Appeal Decision

Appeal Ref: APP/R5510/D/20/3261556

11 Acacia Avenue, Hayes UB3 2NB

- The appeal is made under section 78 of the Town and Country Planning Act 1990 against a refusal to grant planning permission.
 - The appeal is made by Ms Kanwarjit Kaur against the decision of the Council of the London Borough of Hillingdon.
 - The application Ref 50341/APP/2020/1681, dated 1 June 2020, was refused by notice dated 28 July 2020.
 - The development proposed is a single storey rear extension.
-

**EXISTING
GROUND FLOOR PLAN**

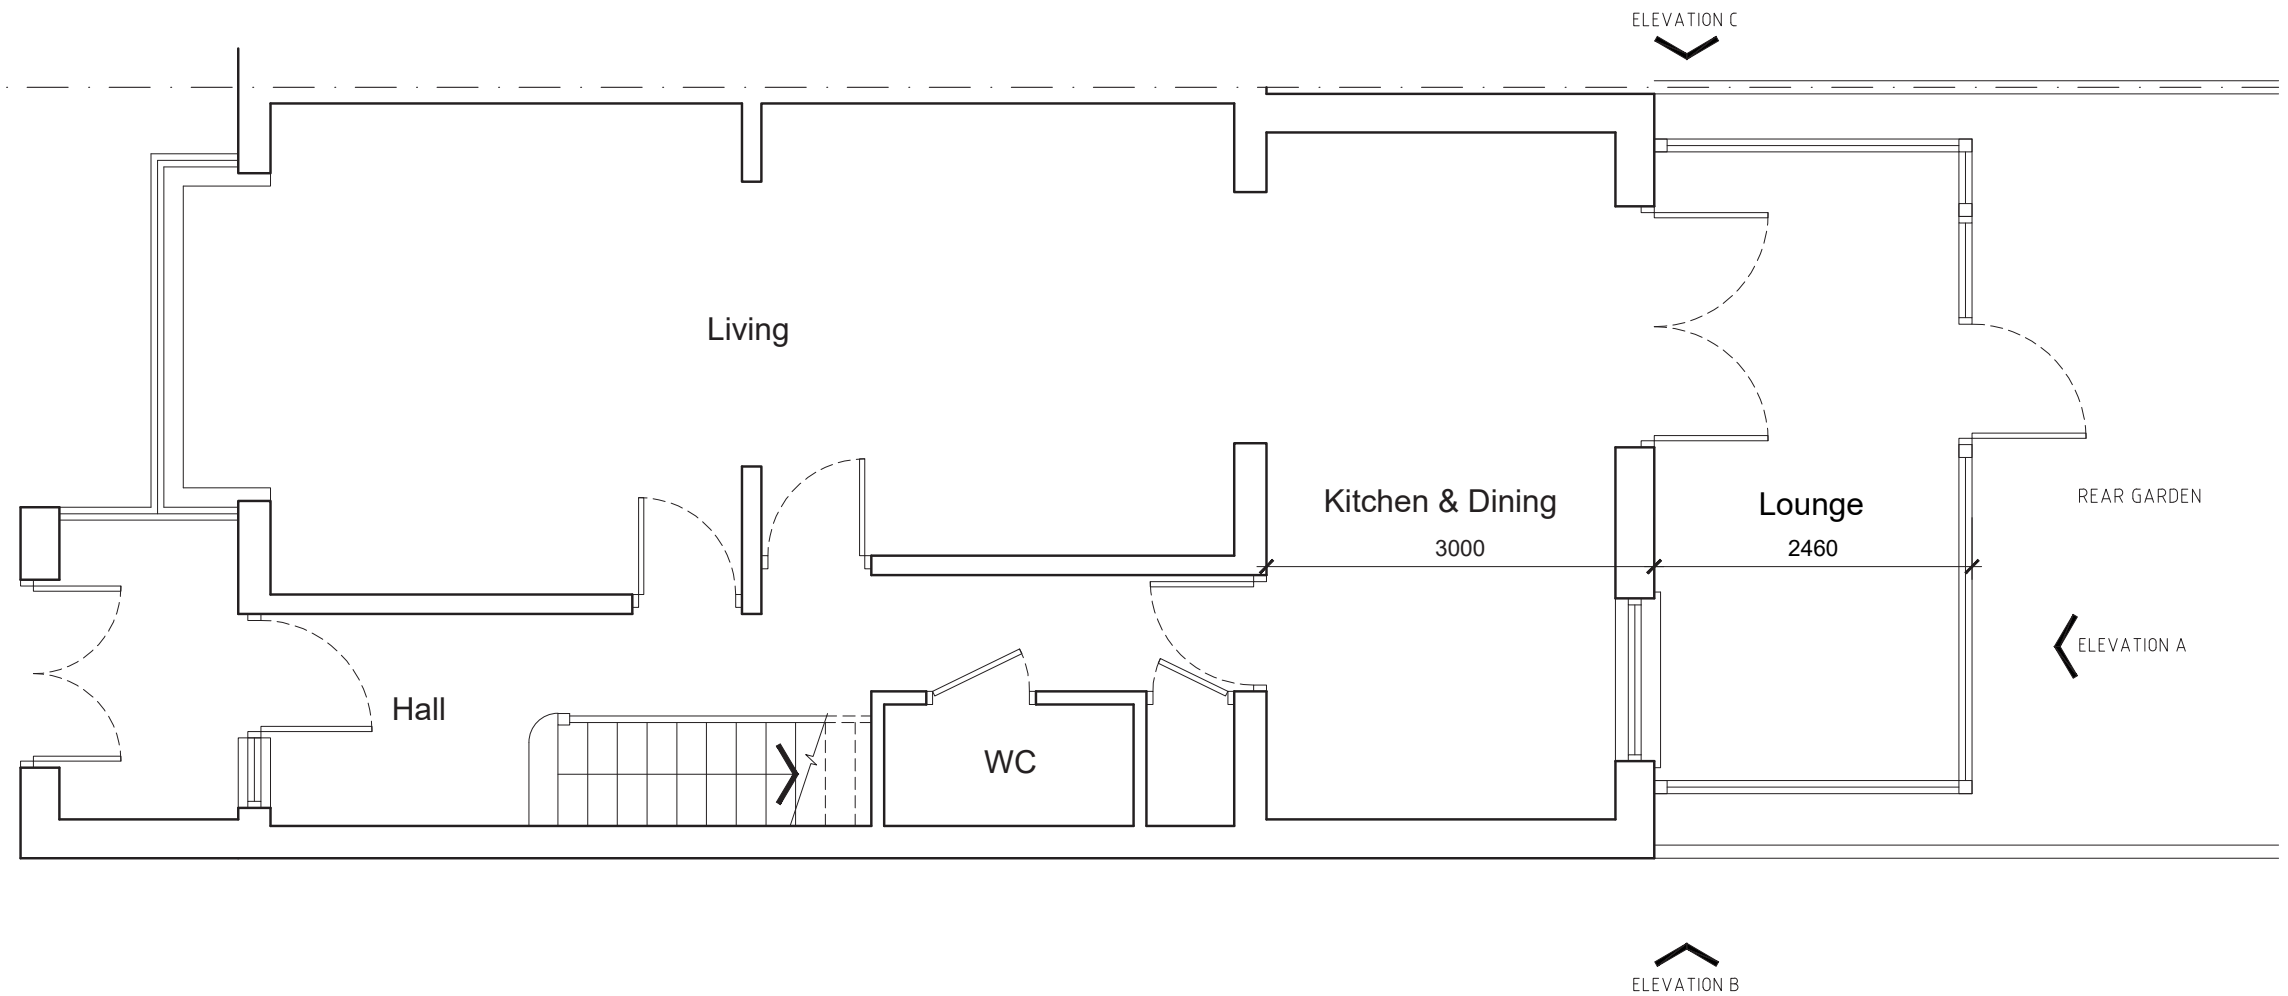
3. The appeal property is an end-of-terrace 2 storey dwelling. It has an existing single storey flat roofed rear extension, at around 3 metres deep, which adjoins the boundary with No 9 Acacia Avenue. There is also a conservatory which extends around 2.46 metres further to the rear. This is set-in from the boundary and it is of lightweight construction due to the predominantly glazed walls. Furthermore, the conservatory is lower than the flat-roofed extension and features a mono-pitched roof that reduces in height to the rear. These factors combine to limit the visual impact of the existing conservatory on the adjoining property at No 9.

**PROPOSED
GROUND FLOOR PLAN**

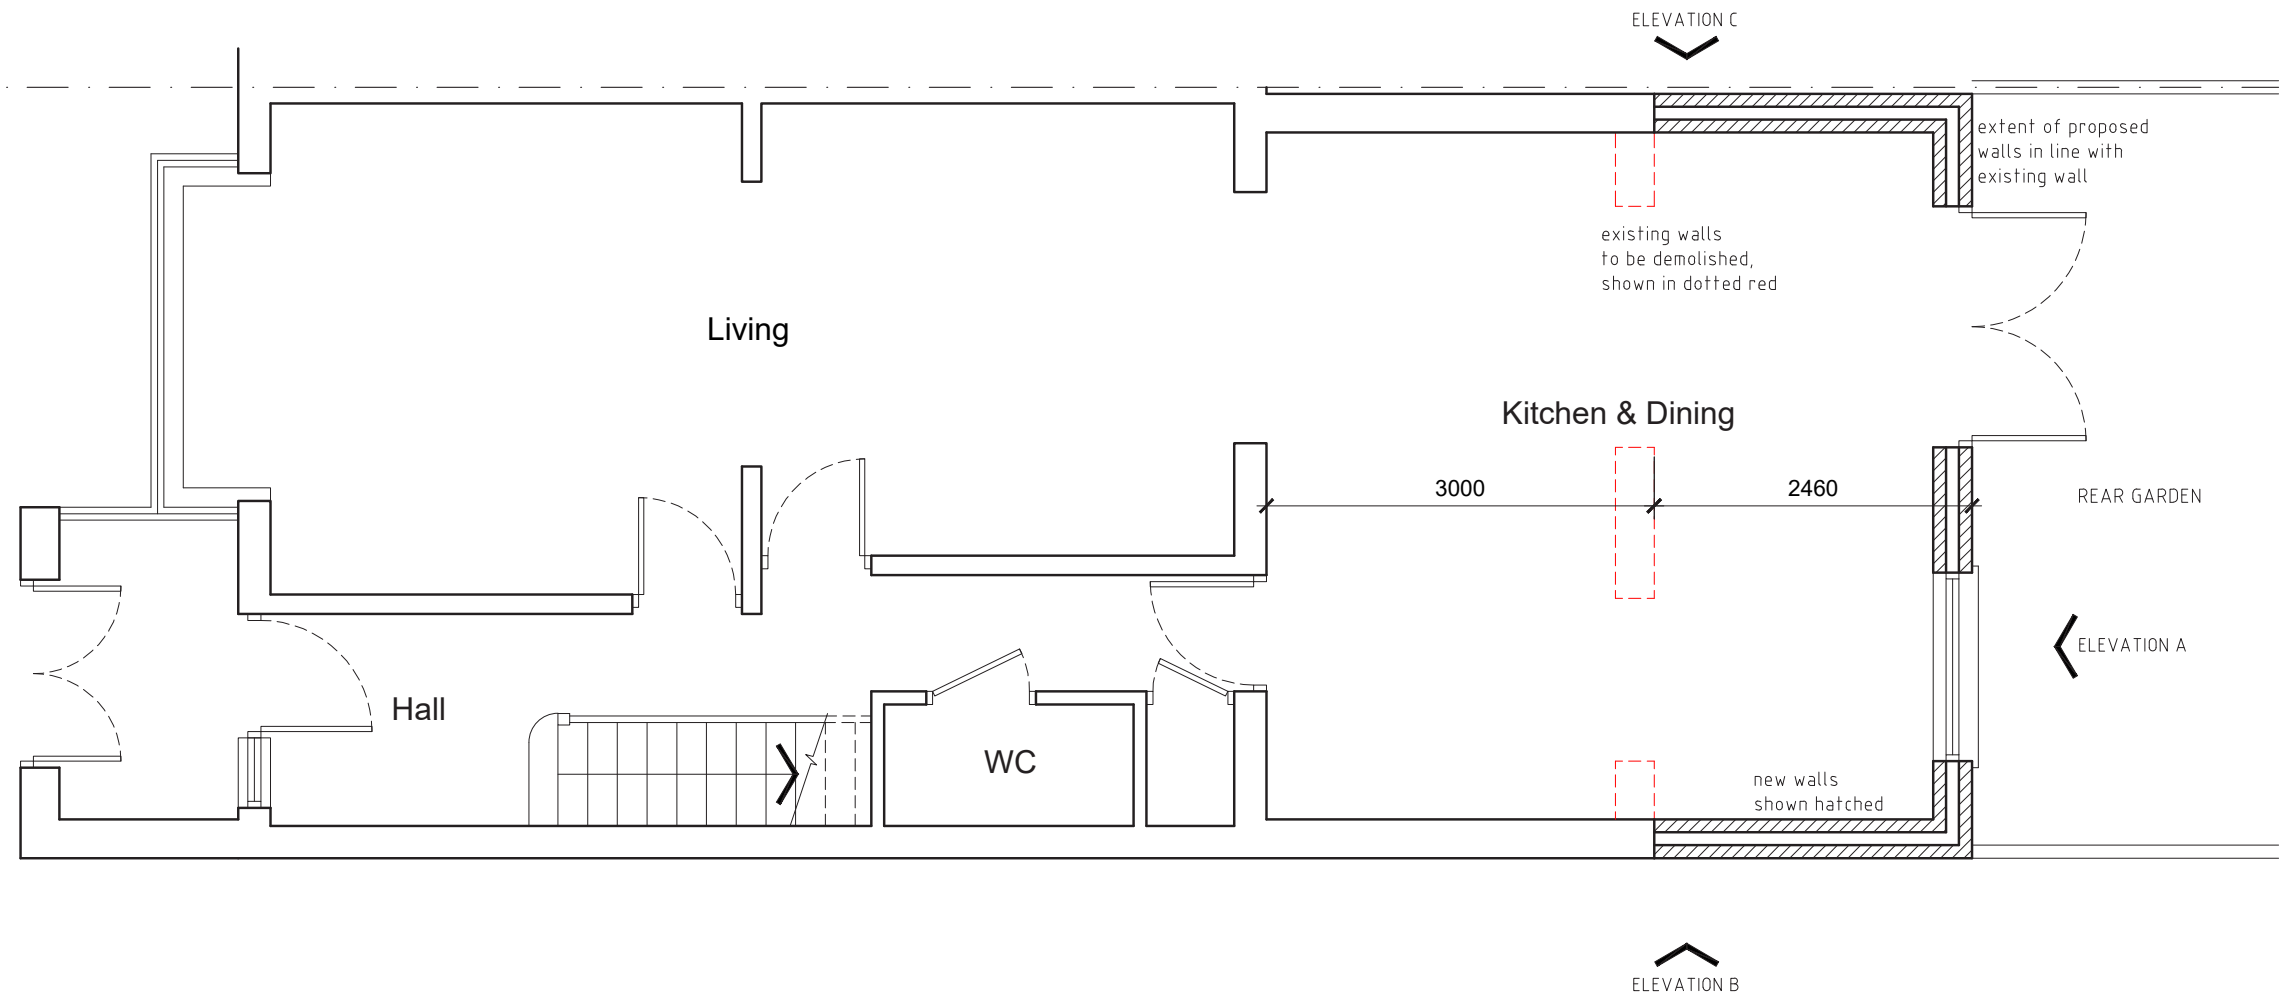
4. The proposed single storey rear extension would replace the conservatory, and it would match the width and height of the existing flat-roofed extension. Whilst the proposal would match the depth of the conservatory, its side wall would be positioned closer to the boundary with No 9 than the conservatory; it would be taller and appear more obtrusive.

**PROPOSED
ELEVATIONS**

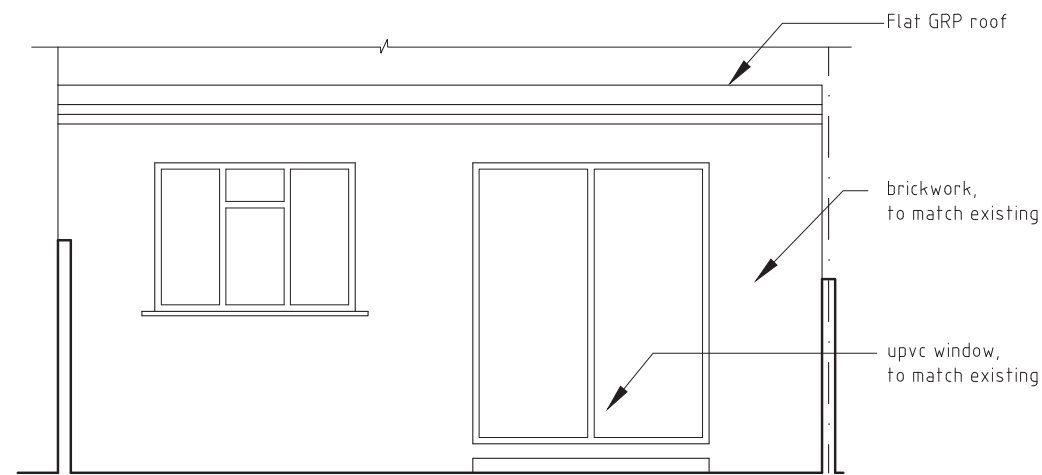
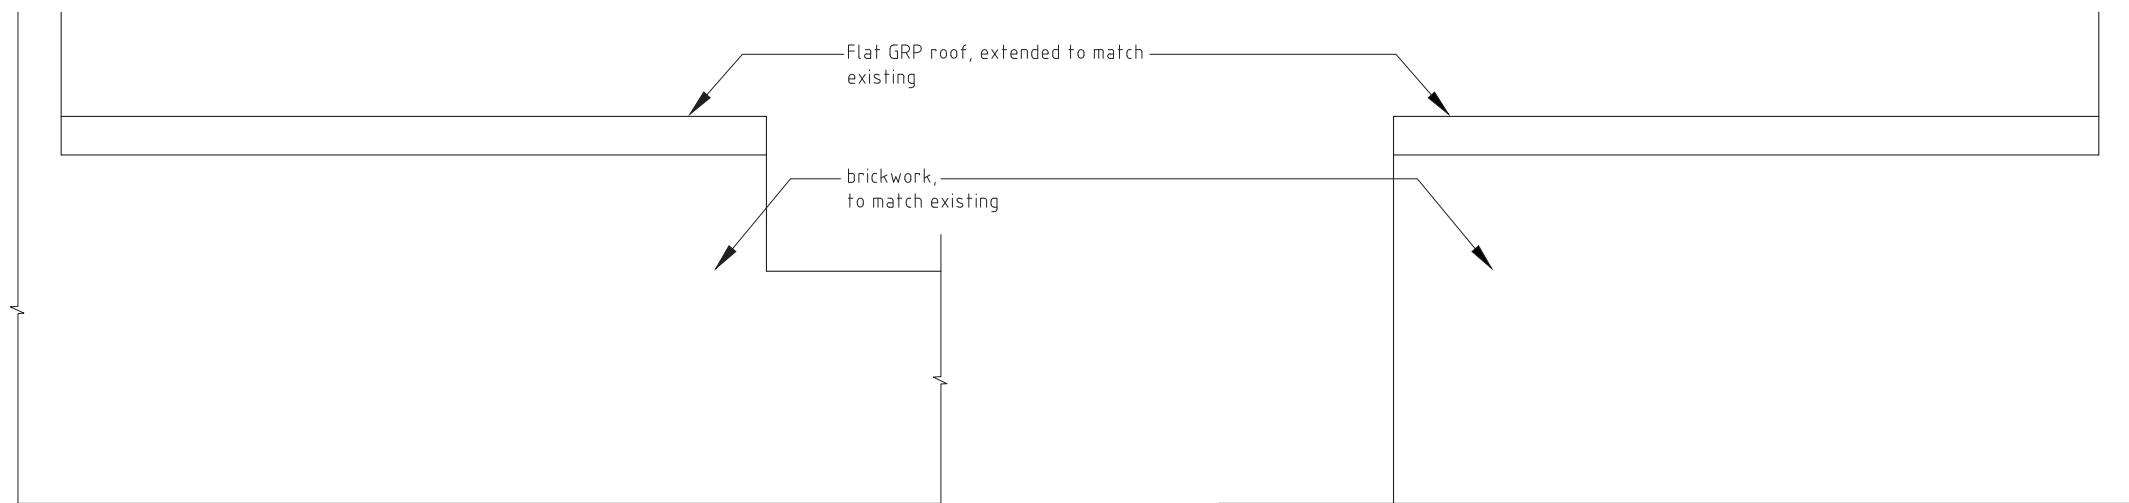
5. The proposal would not cause a significant loss of light to the habitable windows and patio area of No 9 in comparison to the existing situation. Nevertheless, the enlargement would form a solid wall at around 3 metres tall adjacent to the boundary, which would extend about 5.46 metres beyond the rear elevation of No 9. This would cause an unacceptable sense of enclosure

and loss of outlook from the nearest ground floor habitable window and the patio area of the neighbouring property.
